Subject: 31 Fore Street Redevelopment  
Comment Response Letter

To facilitate the review, City and reviewer comments are provided on separate pages below in italics followed by Acorn Engineering, Inc.'s response. The comments were attached to the City Planning Division's Memo dated February 5<sup>th</sup>, 2016.

PAVEMENT SAWCUT DETAIL
NOT TO SCALE

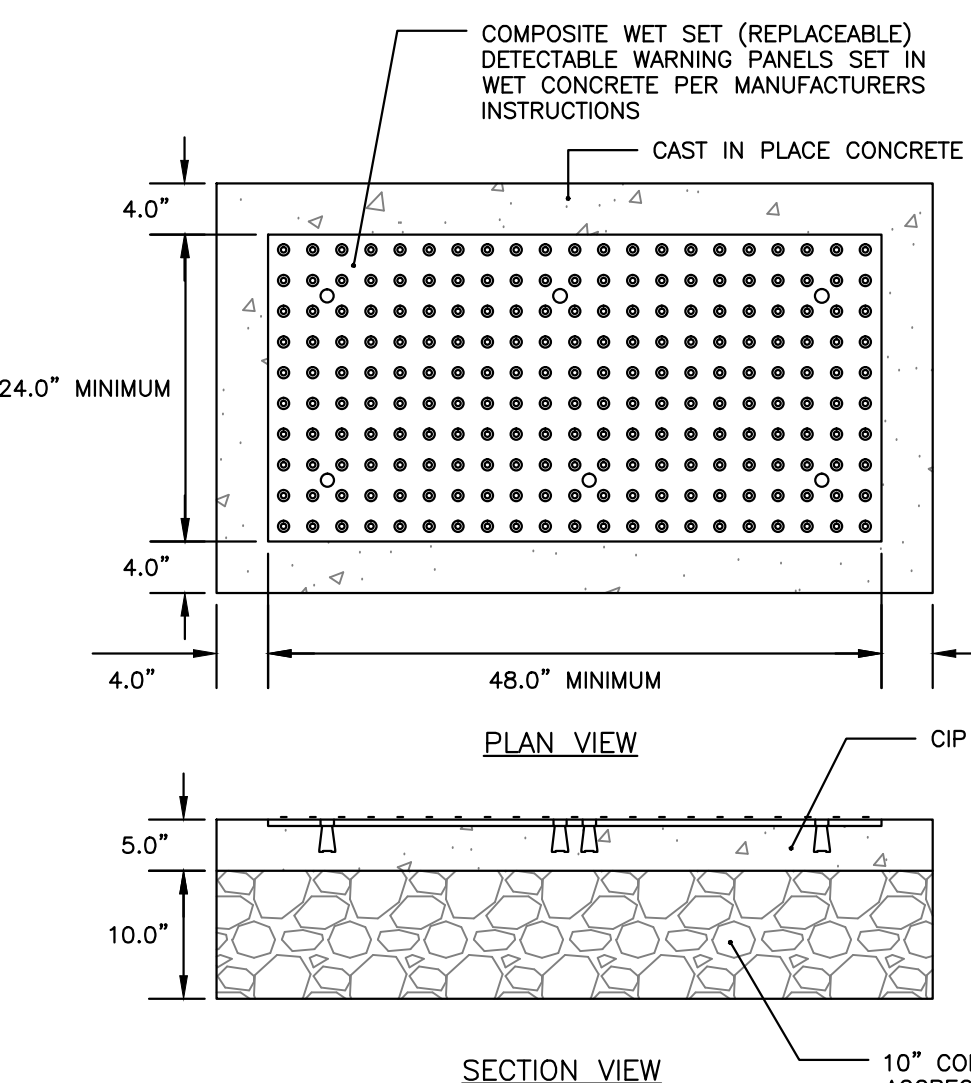
**Comment** – *Pavement saw cut lines should be shown for the utility connections within Waterville Street.*

**Response** – Pavement saw cut lines for utilities have been added to C-20 of the Civil Plan Set; refer to the attachments for an updated plan set.

DRIVEWAY APRON LAYOUT DETAIL
NOT TO SCALE

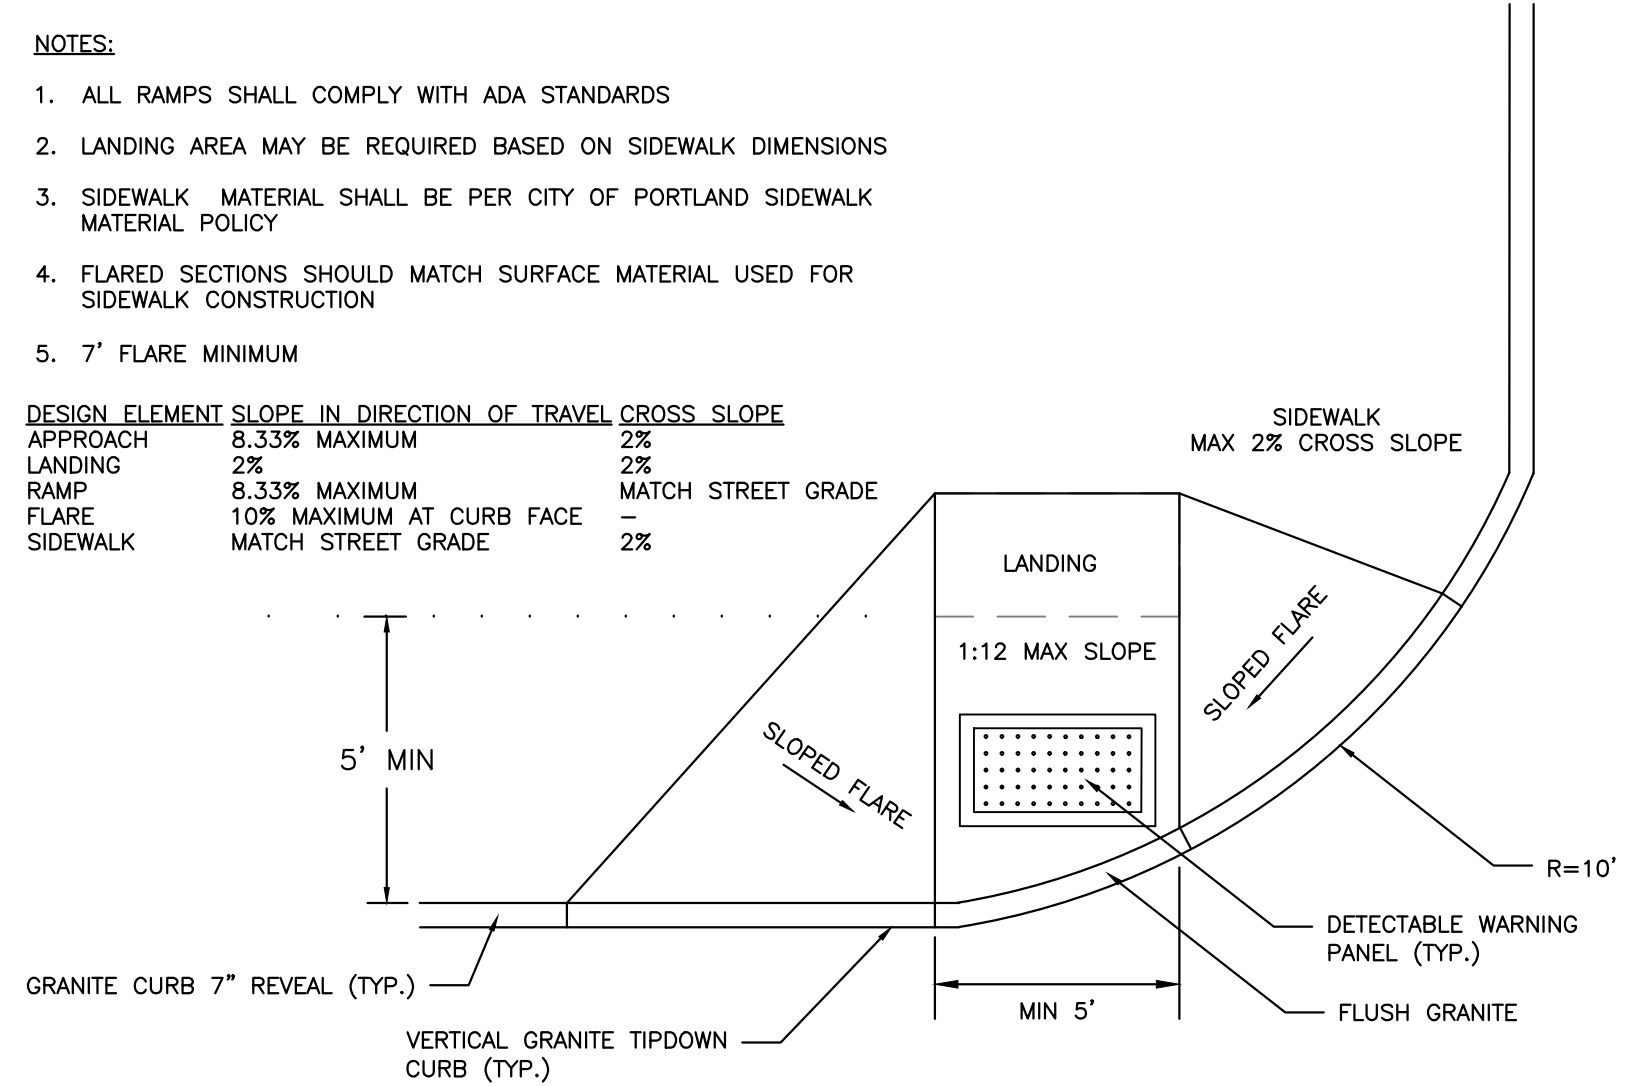
**Comment** – *The proposed 12'-4" wide driveway on Waterville St. has an approximate 31' separation from the street corner as measured from the center of the drive to the street right of way (corner) of Fore St. Code requires 35'. Please try to make up the additional four feet by reducing the drive cut to 12', reduce the aisle width from 25'-8" to 24' and incorporate compact parking spaces (8' X 15') in an innovative manner.*

**Response** – Due to architectural constraints it is not feasible for the driveway to be moved, allowing for a maximum 31.26' from Fore Street without a significant redesign of the living spaces above the garage. The driveway was reduced from 12'-4" to 12' and moved 6" to be flush with the building edge from our prior submission to increase the setback by 8".

TREE PROTECTION DETAIL
NOT TO SCALE

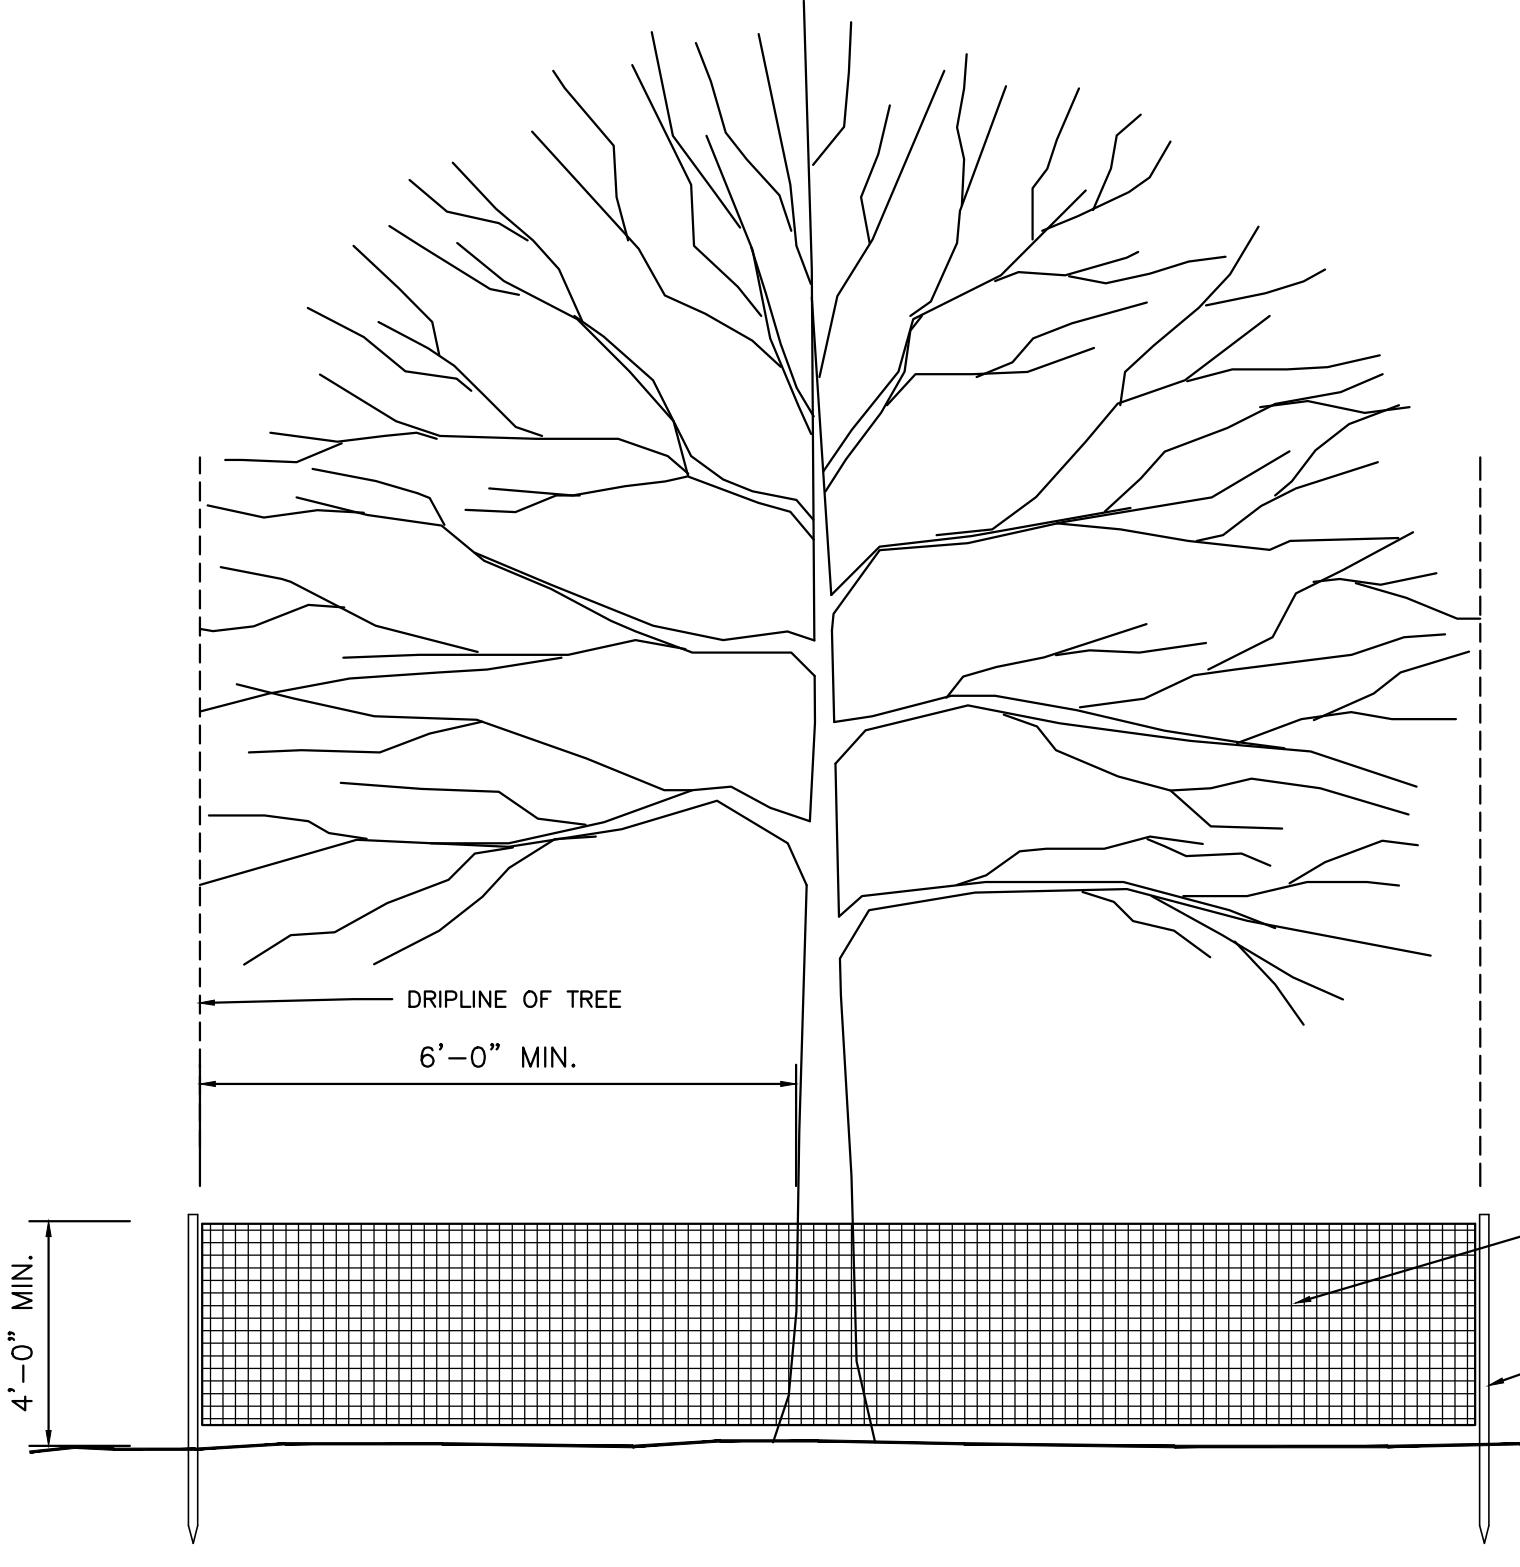
**Comment** – *The street tree along Fore Street should be protected during construction, any broken branches damaged should be pruned as part of the project.*

**Response** – The street tree along Fore Street is to remain and be protected as noted in C-10 and in accordance with the detail outlined in C- 41.

GRANITE STREET MONUMENT
NOT TO SCALE

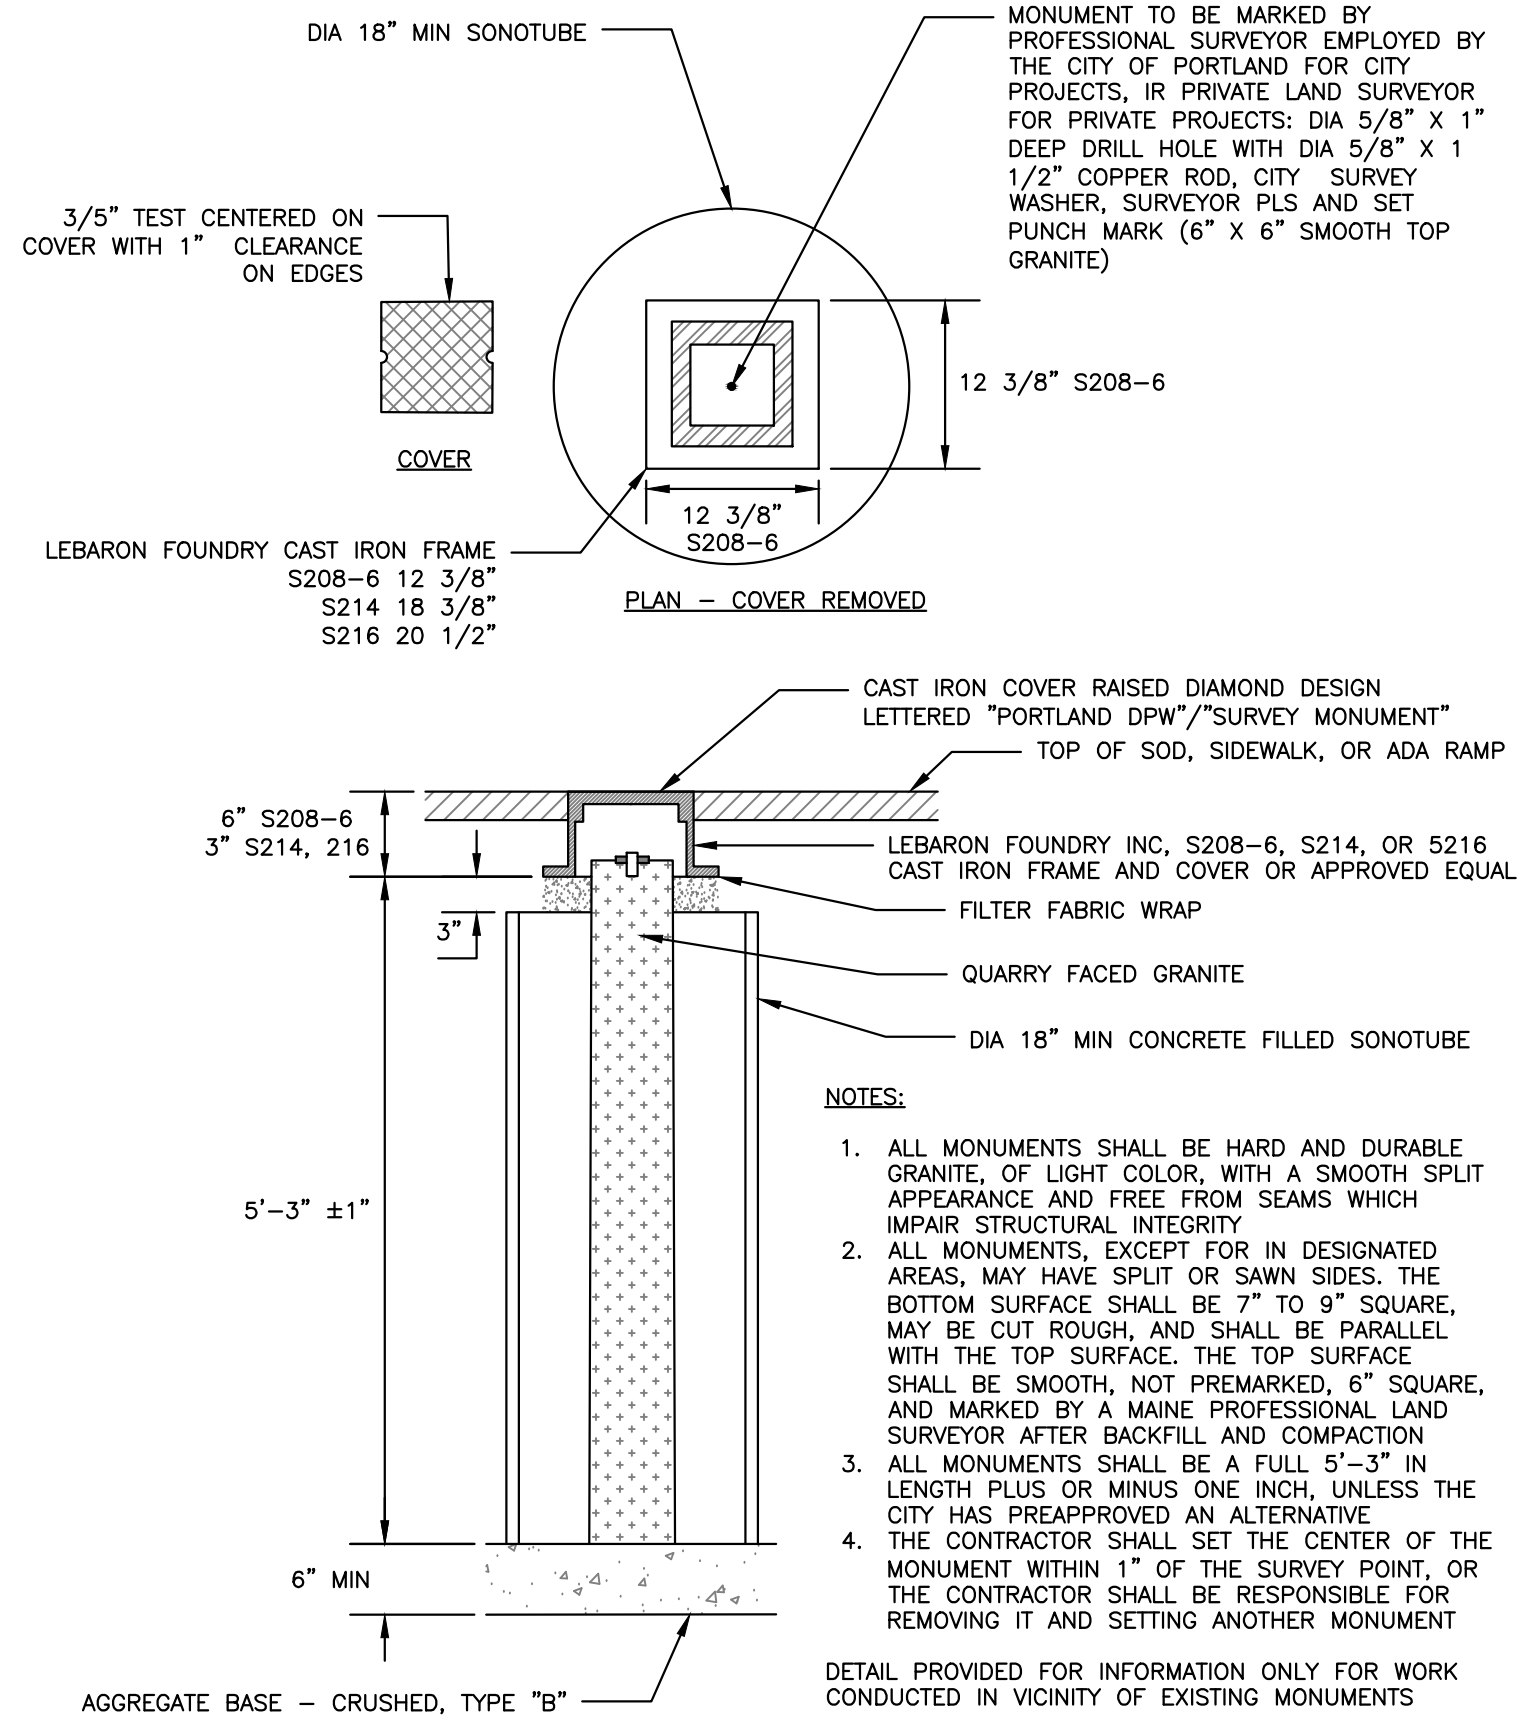
**Comment** – *Add State Plane Coordinates for the property corners and three foot offset monument to be set. Show the monument to be set on the Site Plan in addition to the Subdivision Plat.*

**Response** – Owen Haskell has provided the design team with a 1 ft. topographic survey that includes State Plane Coordinates and offset monuments; the updated survey is included in the final submission. The Subdivision Plat has been also updated to show the new survey and highlights the monuments.

SOIL FILTER CROSS SECTION

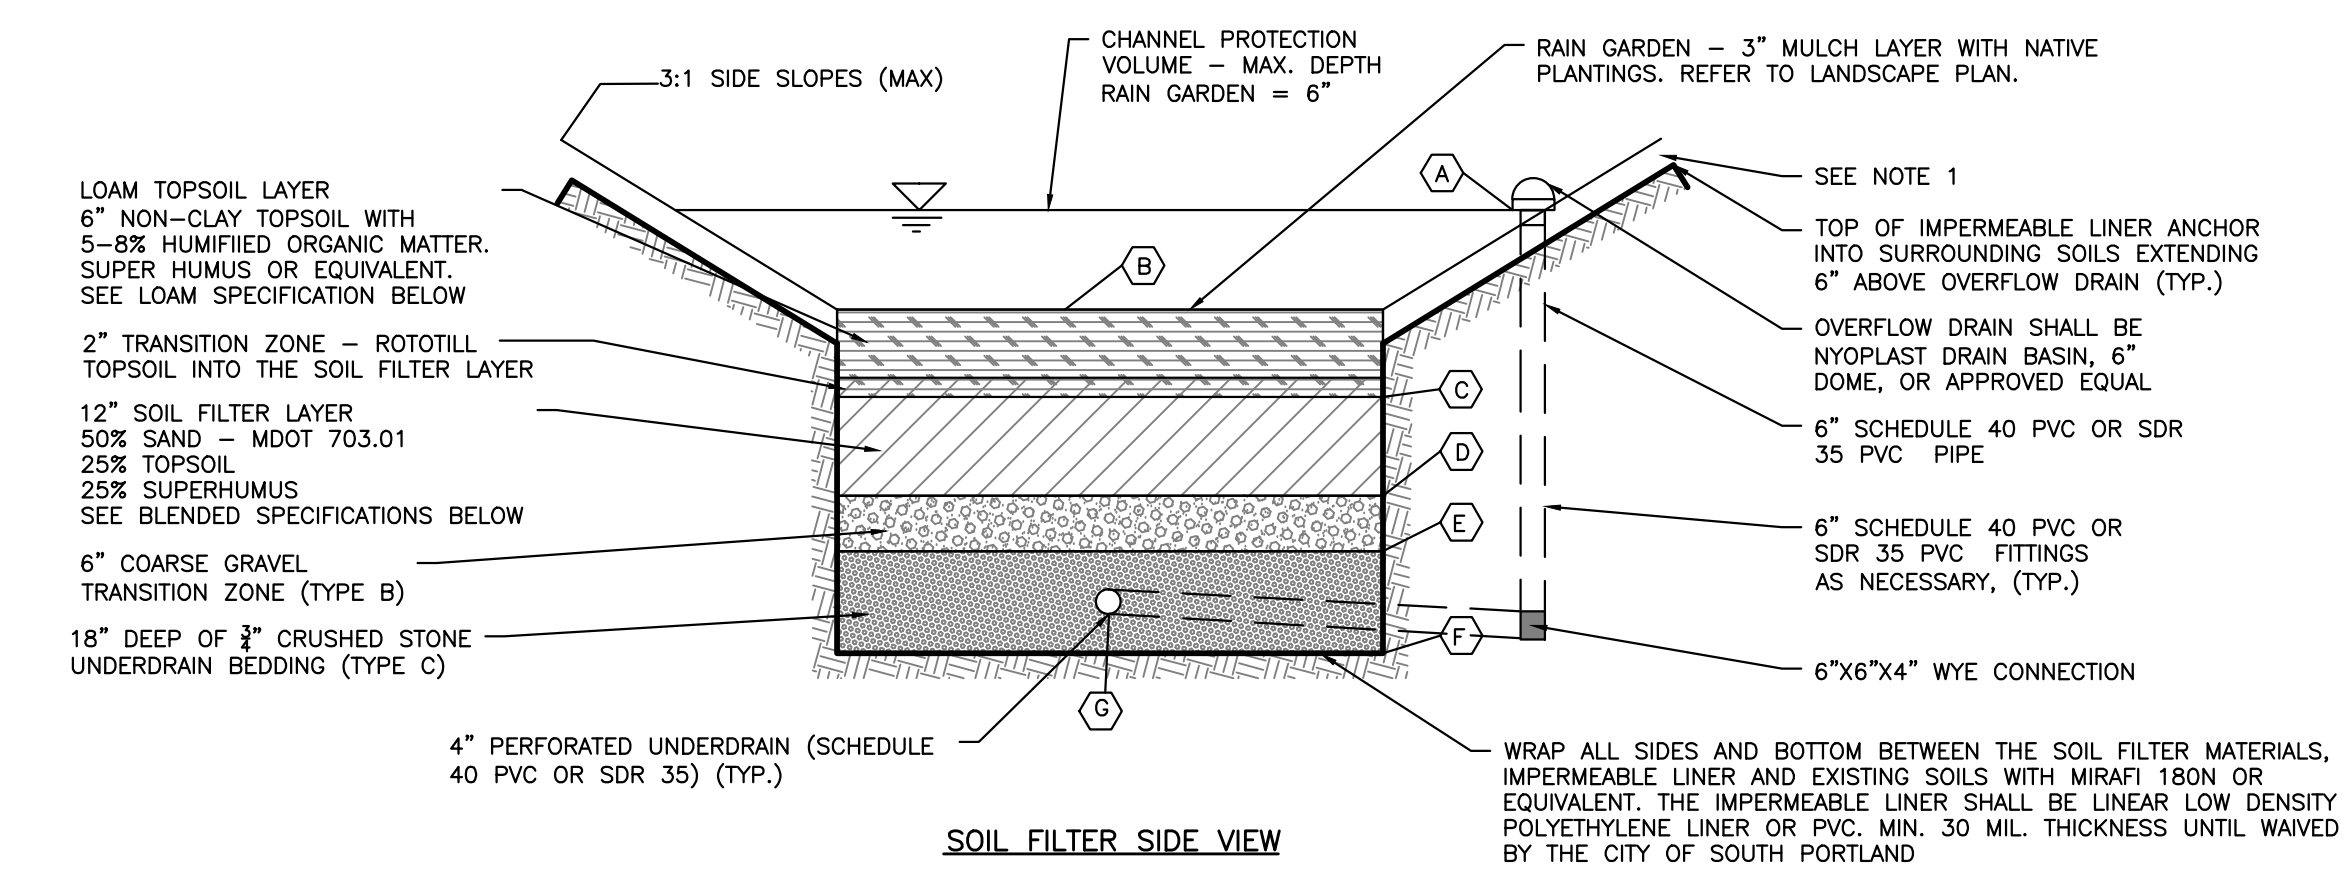
- b) *General Standards: The project will result in a net increase of impervious area of just below 1,000 SF, as such, the project is not required to include stormwater management features for stormwater quality control. The Applicant has proposed to construct a rain garden to capture and treat stormwater runoff. We find this to be an acceptable approach for stormwater management for the site. We request additional grading detail be added to the site plan in and around the rain garden to understand how the rain garden in-slopes will transition to the building wall and the adjacent sidewalk. Also, a stabilized discharge location for the roof water into the raingarden should be identified in the Final submittal.*

**Comment** – *Specific details on the rain garden are requested, if the project is to qualify for 'Stormwater' credits the project should follow Portland Water Resources 'rain garden' guidelines.*

**Response** – Thank you for your review. C-30 has been revised and updated to reflect greater grading detail in and around the rain garden as well as a stabilized location for the rainwater discharge. A detail of the rain garden with grades and stabilized discharges was also added to C-43.

**Response** – As per City requests, C-30 has been updated and revised to show greater detail in how the rain garden is to be implemented and graded; additional information is provided in C-43. The rain garden shall be populated by species as noted in the Plant Schedule on the landscaping plan. These species comply with those recommended and approved by the Maine DEP Best Management Practices guidelines.
